Subject: 3rd Party Planning Application - 22/02647/F

Our DTS Ref: 70358  
Your Ref: 22/02647/F

Re: Unit 6, Oxford Technology Park, Technology Drive, -, Kidlington, OXFORDSHIRE , OX5 1RE

3052 OFFICE 01.XX.M2.C.0200_Drainage Design

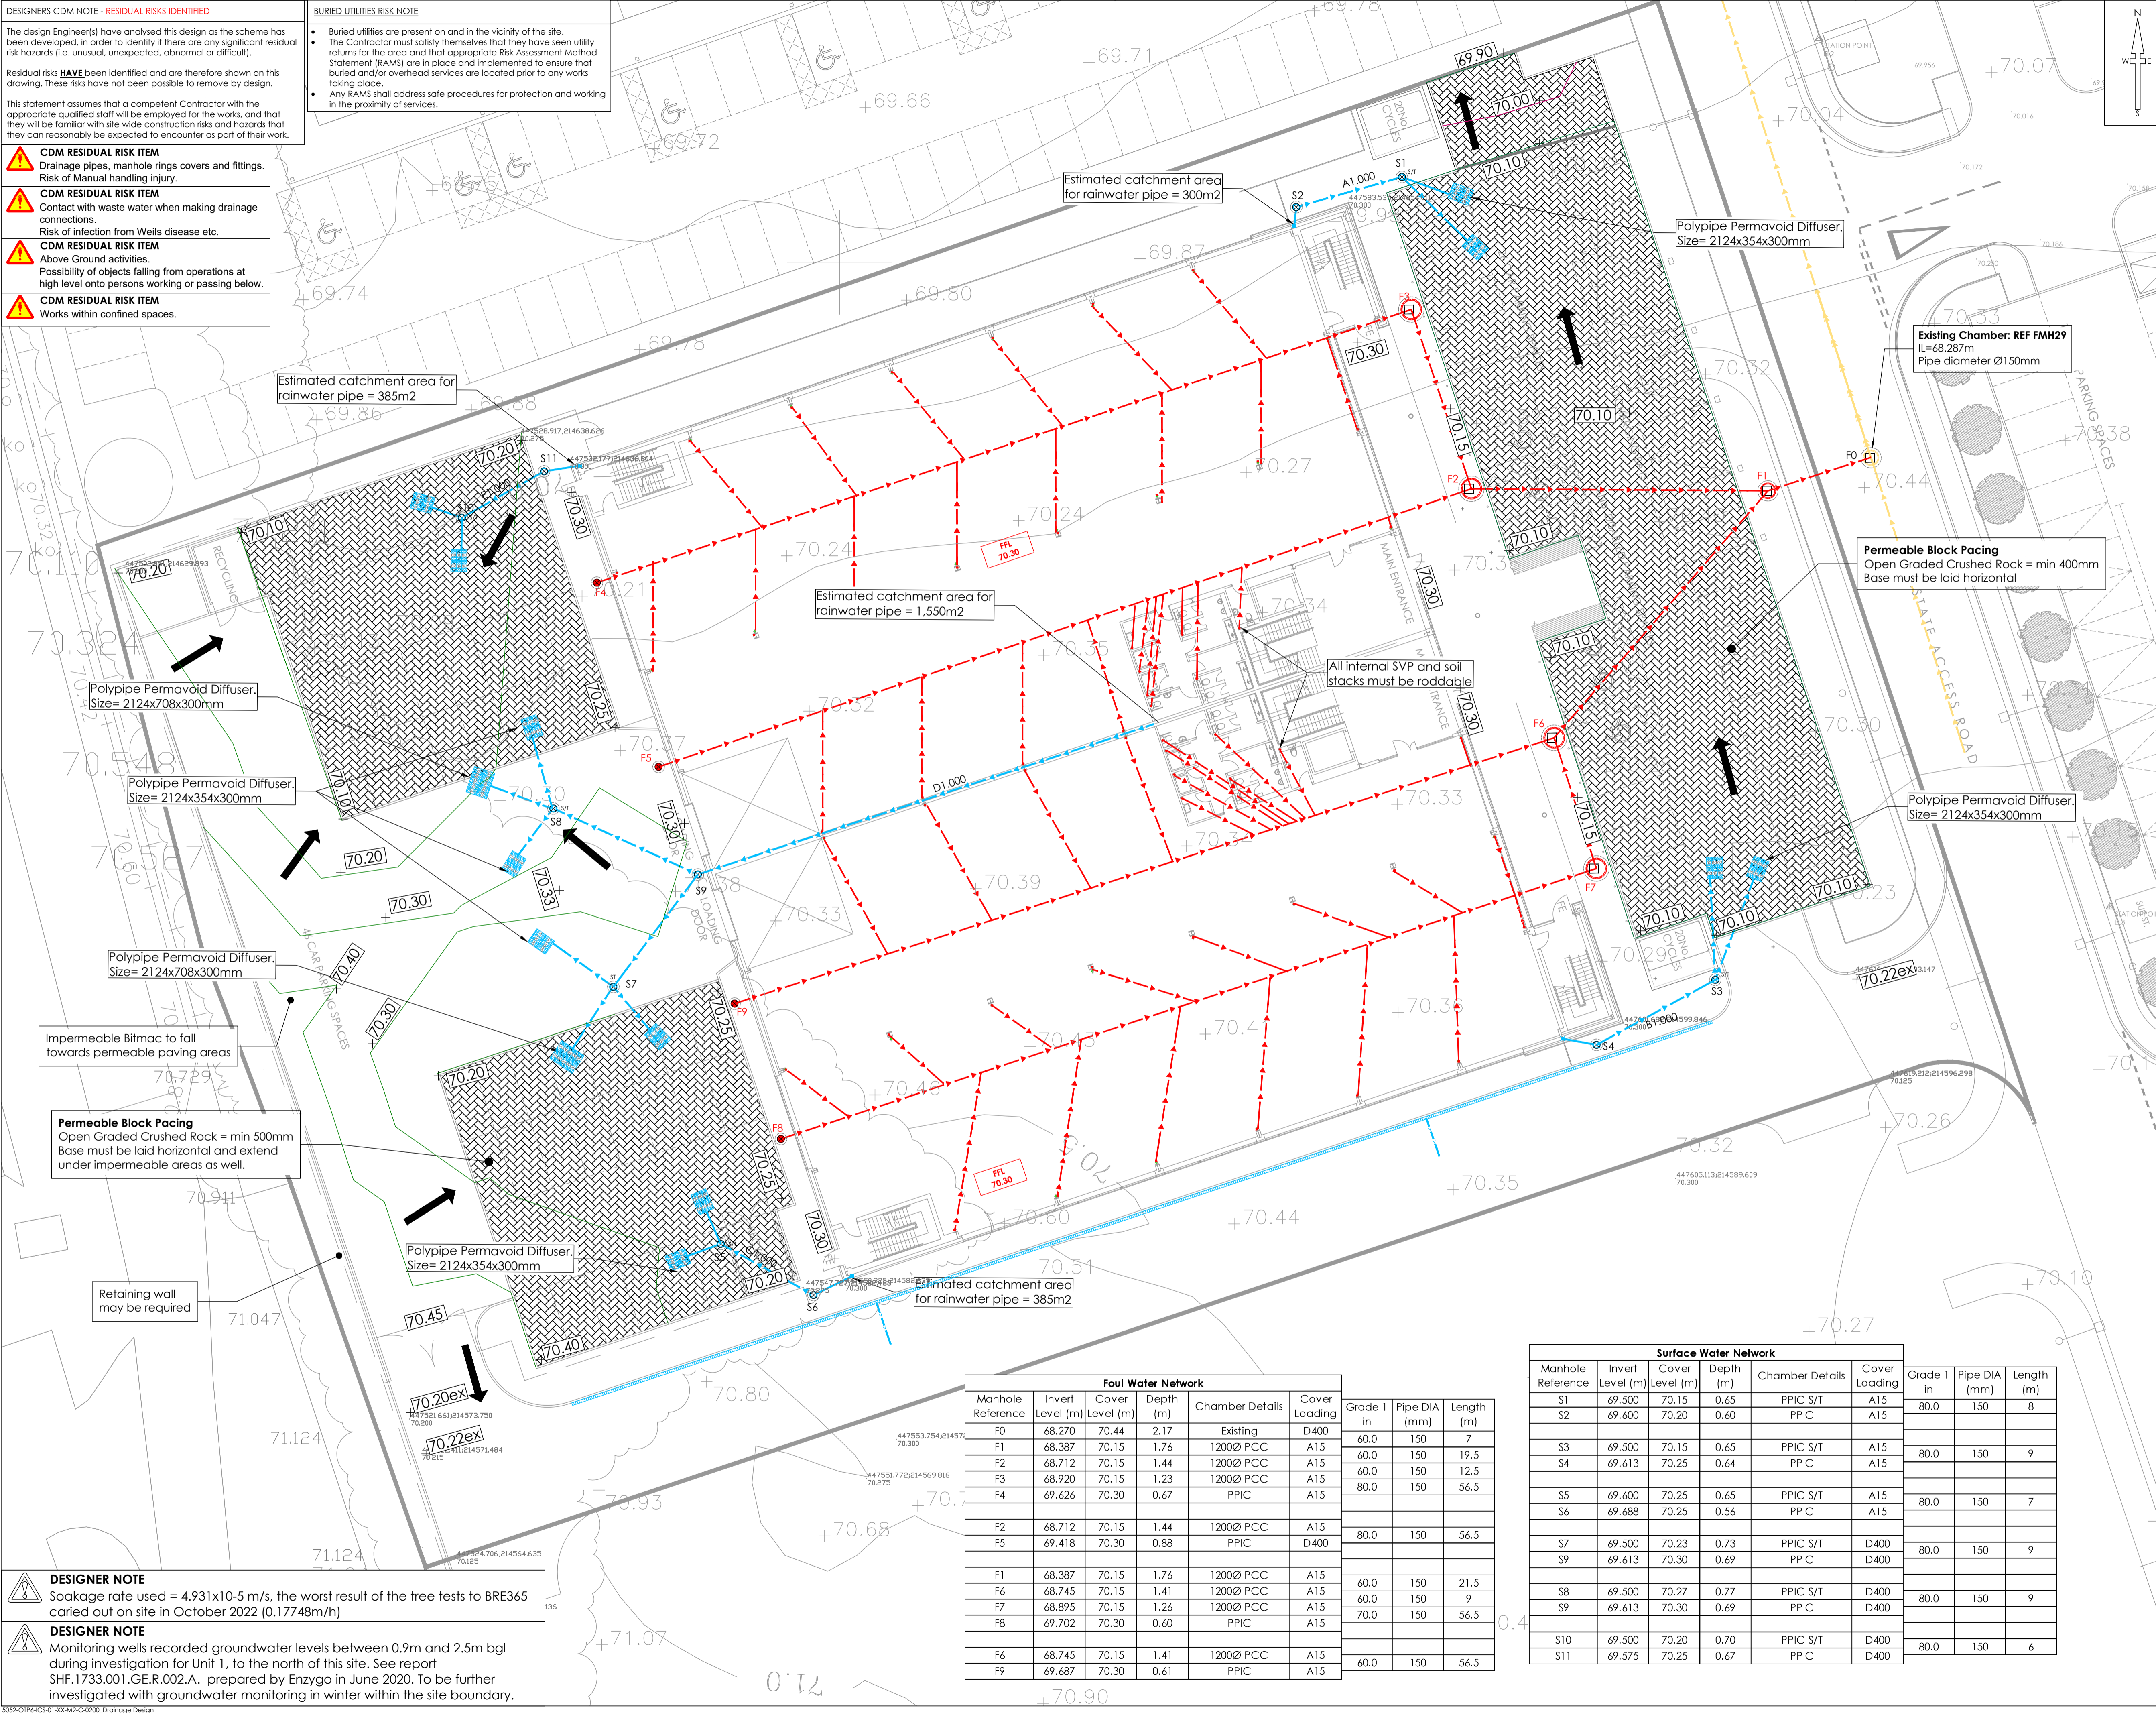
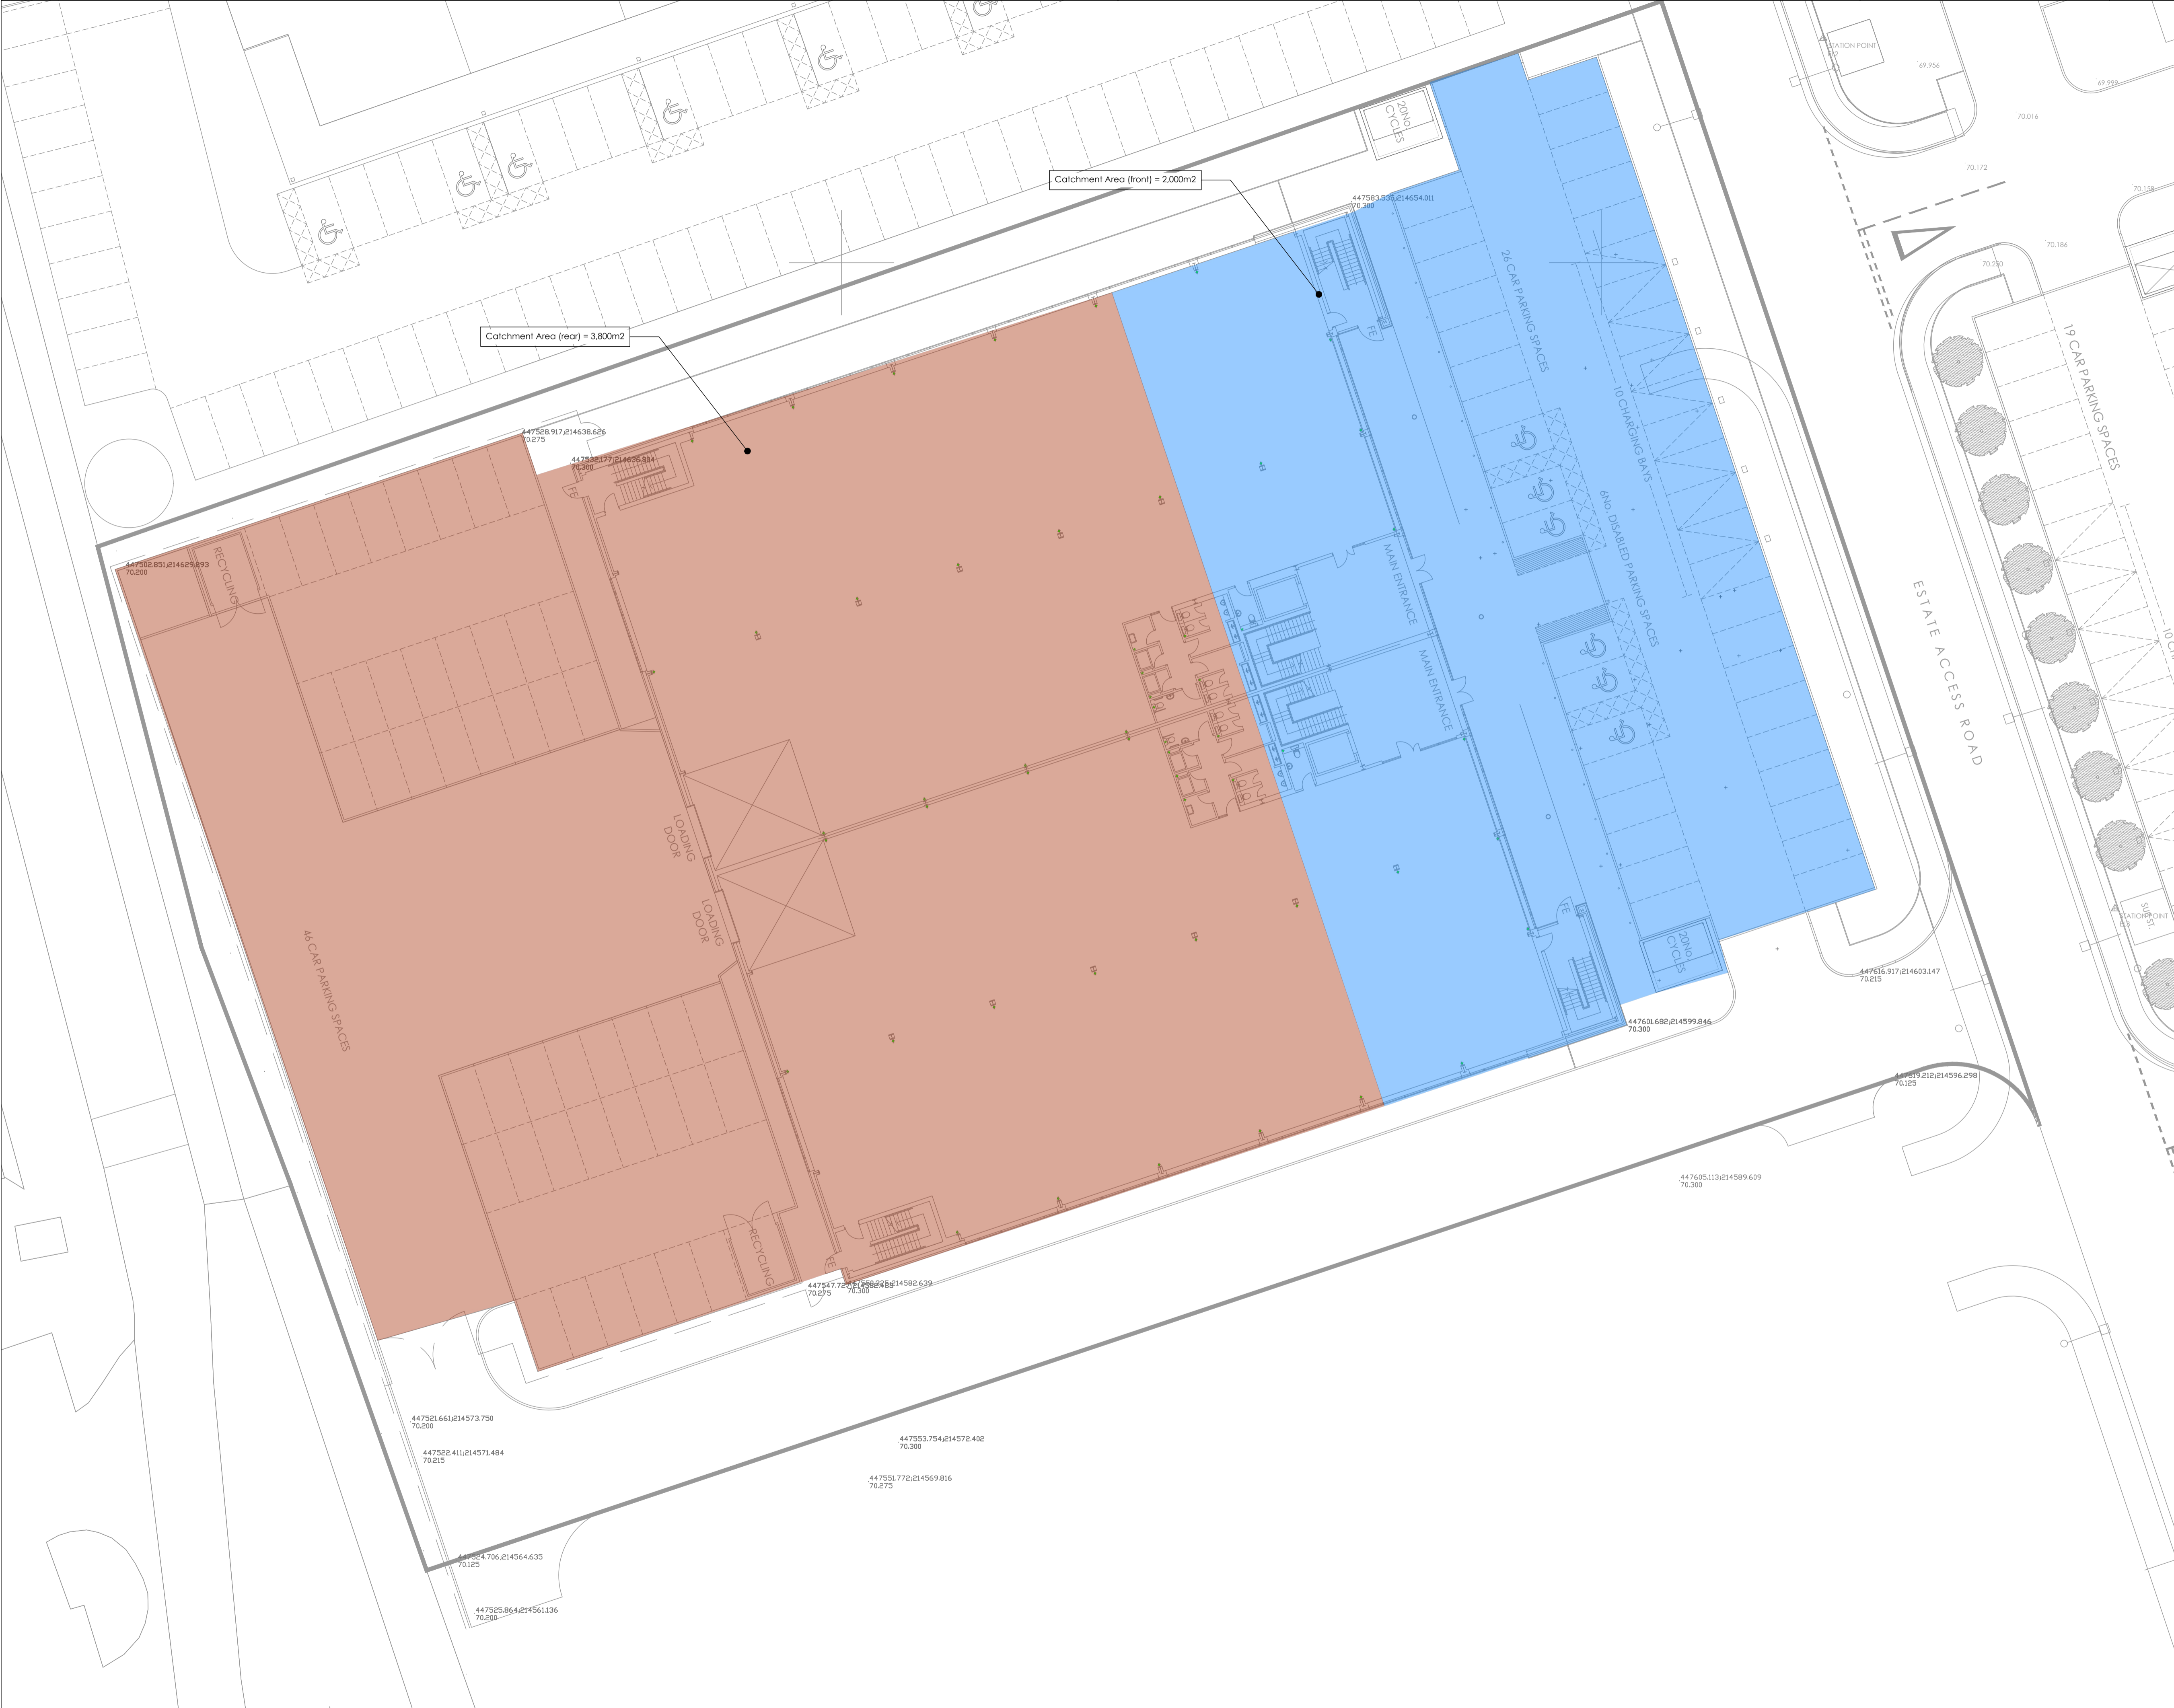
Please provide a drainage strategy for this development including Manhole references for where you will connect, connection method (gravity or pumped) and flow rates.
